Phone: 0300 123 6780  
Email: developeras@lancashire.gov.uk  
Your ref: 3/2025/0291  
Our ref: 3/2025/0291/HDC/KW  
Date: 08 May 2025

**Location:** 36 Painter Wood Whalley Old Road Billington BB7 9JD  
**Proposal:** Regularisation of landscaping and engineering works to create extended parking area to front and terracing at the rear and new summer house to rear.  
**Grid Ref:** 372760 435573

drawing title:  
PROPOSED SITE PLAN

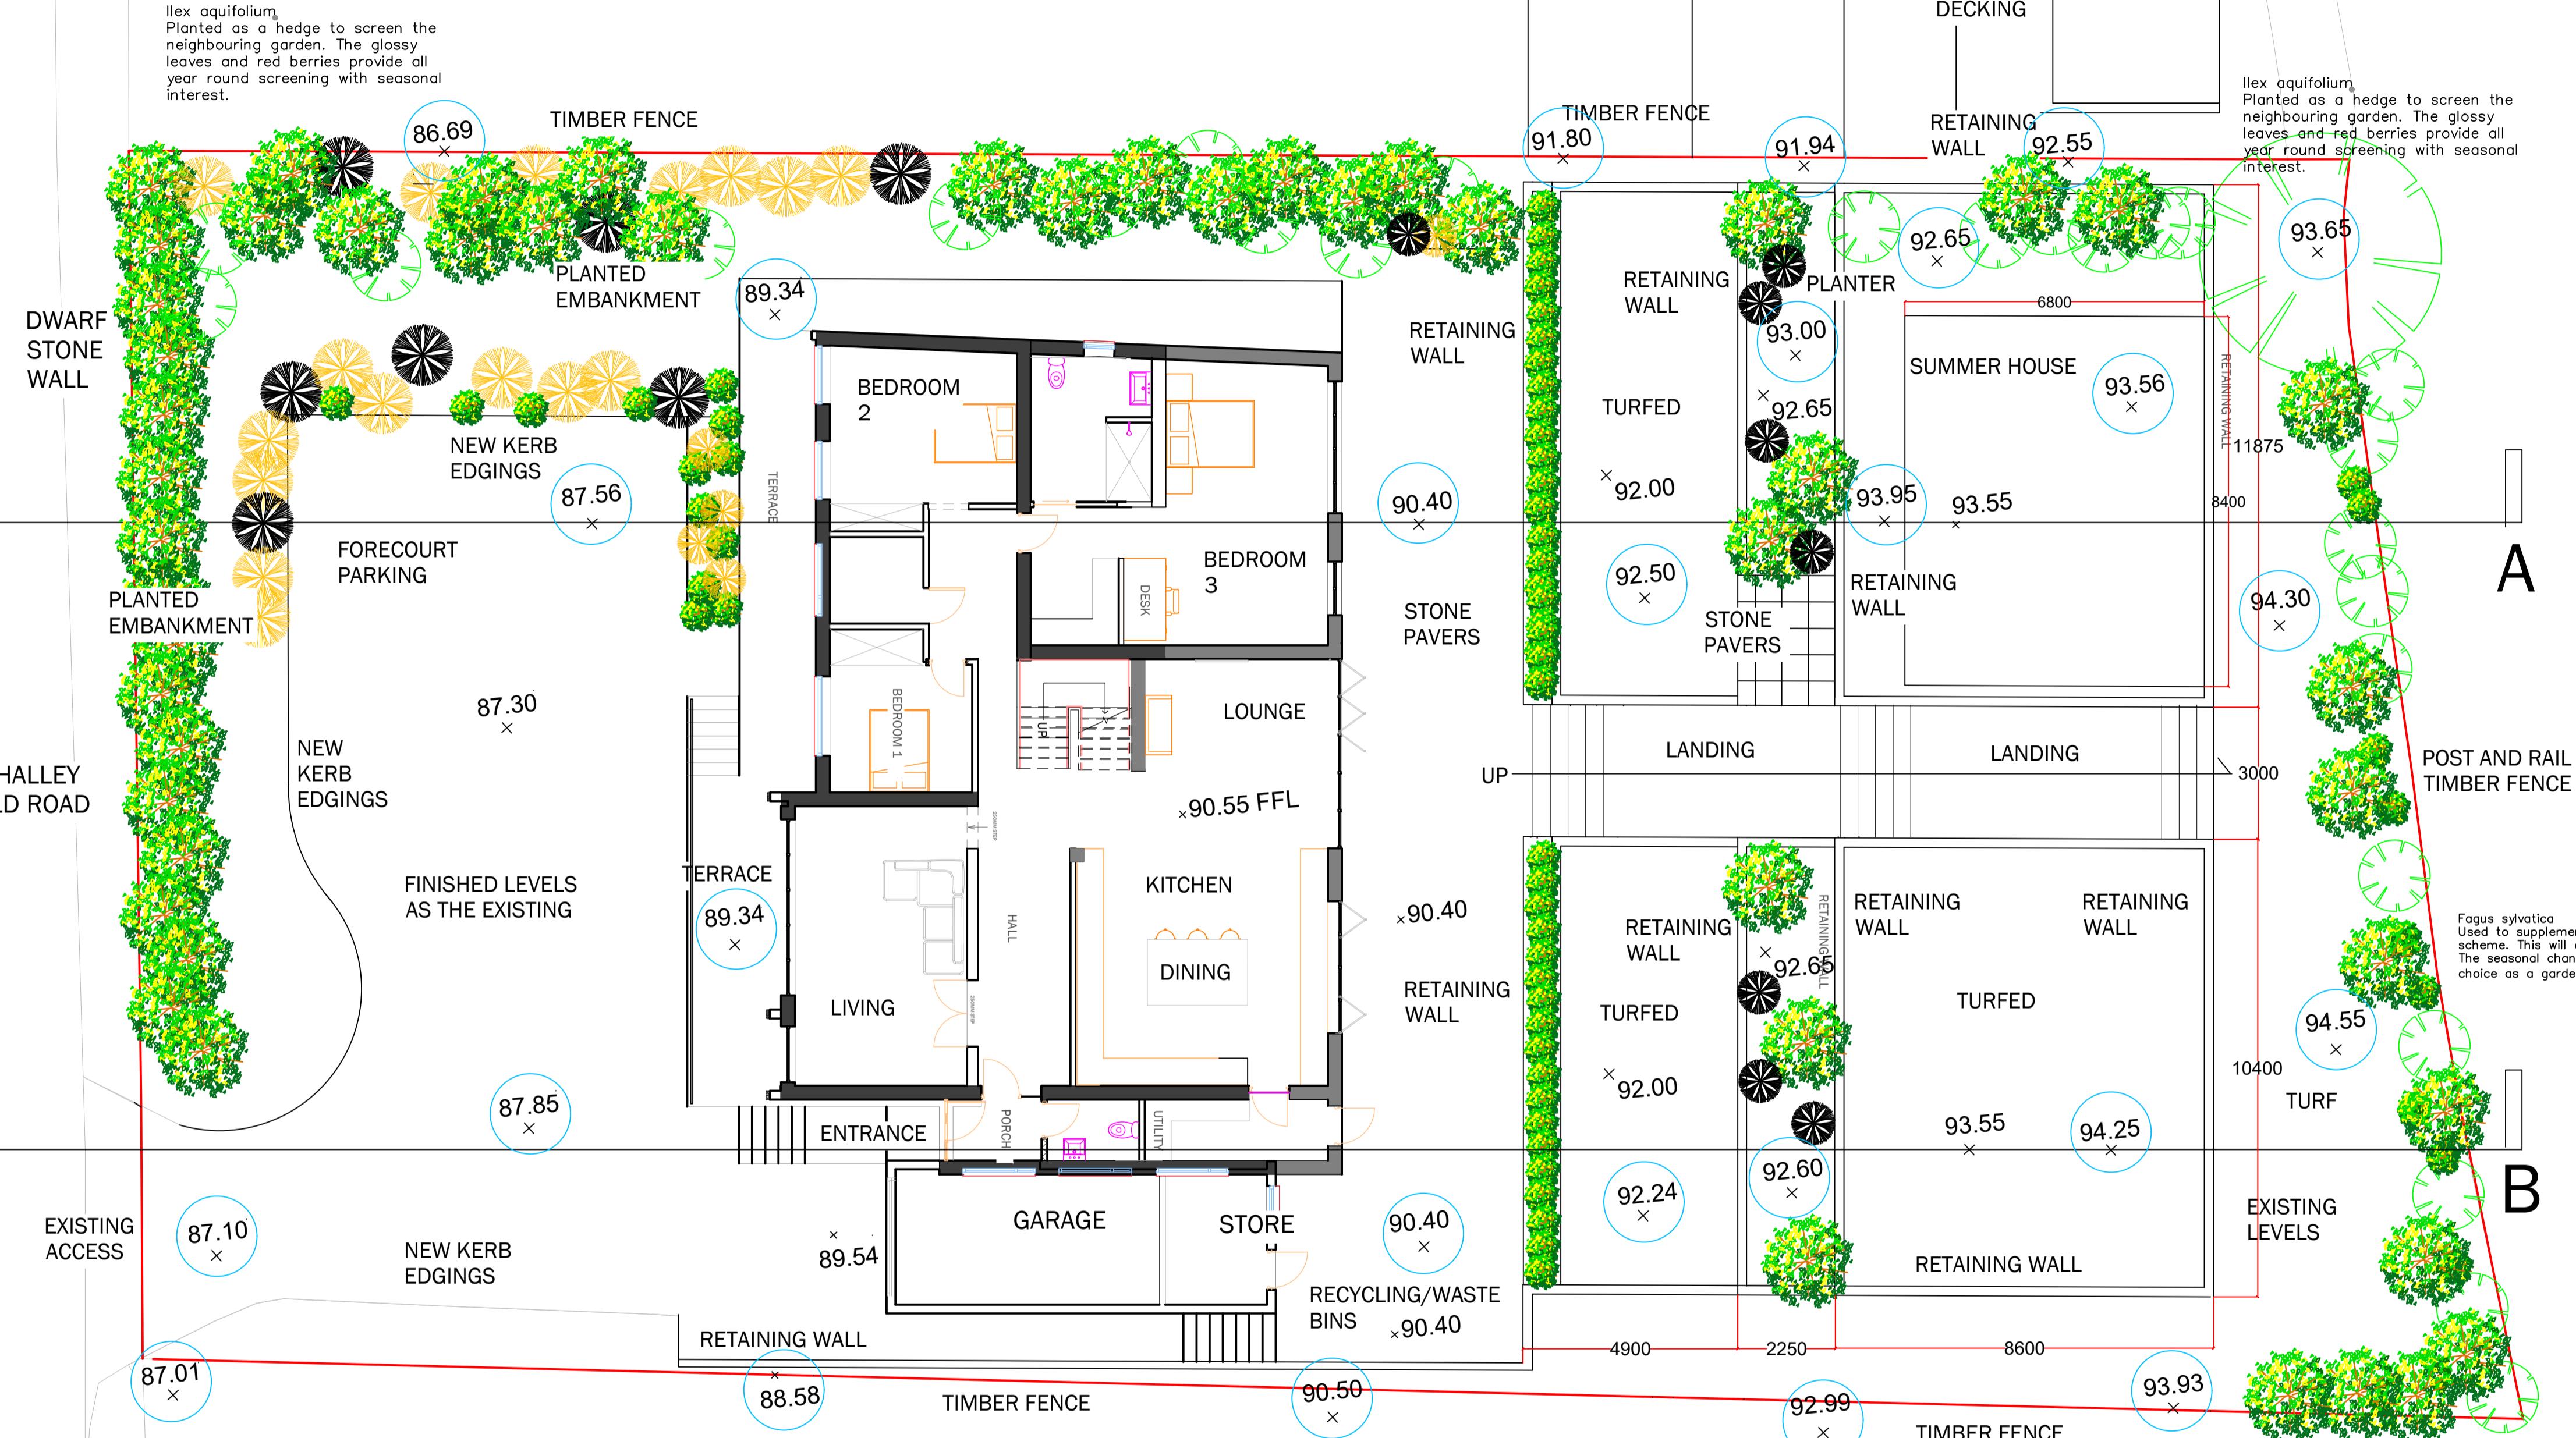
The LHA are aware that the dwelling will continue to be accessed off Whalley Old Road which is an C classified road subject to a 30mph speed limit. The proposal includes works to the existing parking area, which will extend the area providing parking and turning provisions for at least 3 vehicles. The improvements are acceptable for the size and nature of the site. The amended driveway should be surfaced in hard material to ensure no debris is dragged onto the highway.

2. Before the widened parking area is used for vehicular purposes, it shall be appropriately paved in tarmacadam, concrete, block pavours, or other hard material to be approved by the Local Planning Authority.

3. The surface water from the approved driveway should be collected within the site and drained to a suitable internal outfall. Prior to commencement of the development details of the drainage strategy shall be submitted to and approved in writing by the Local Planning Authority. The scheme shall be implemented in accordance with the approved details.
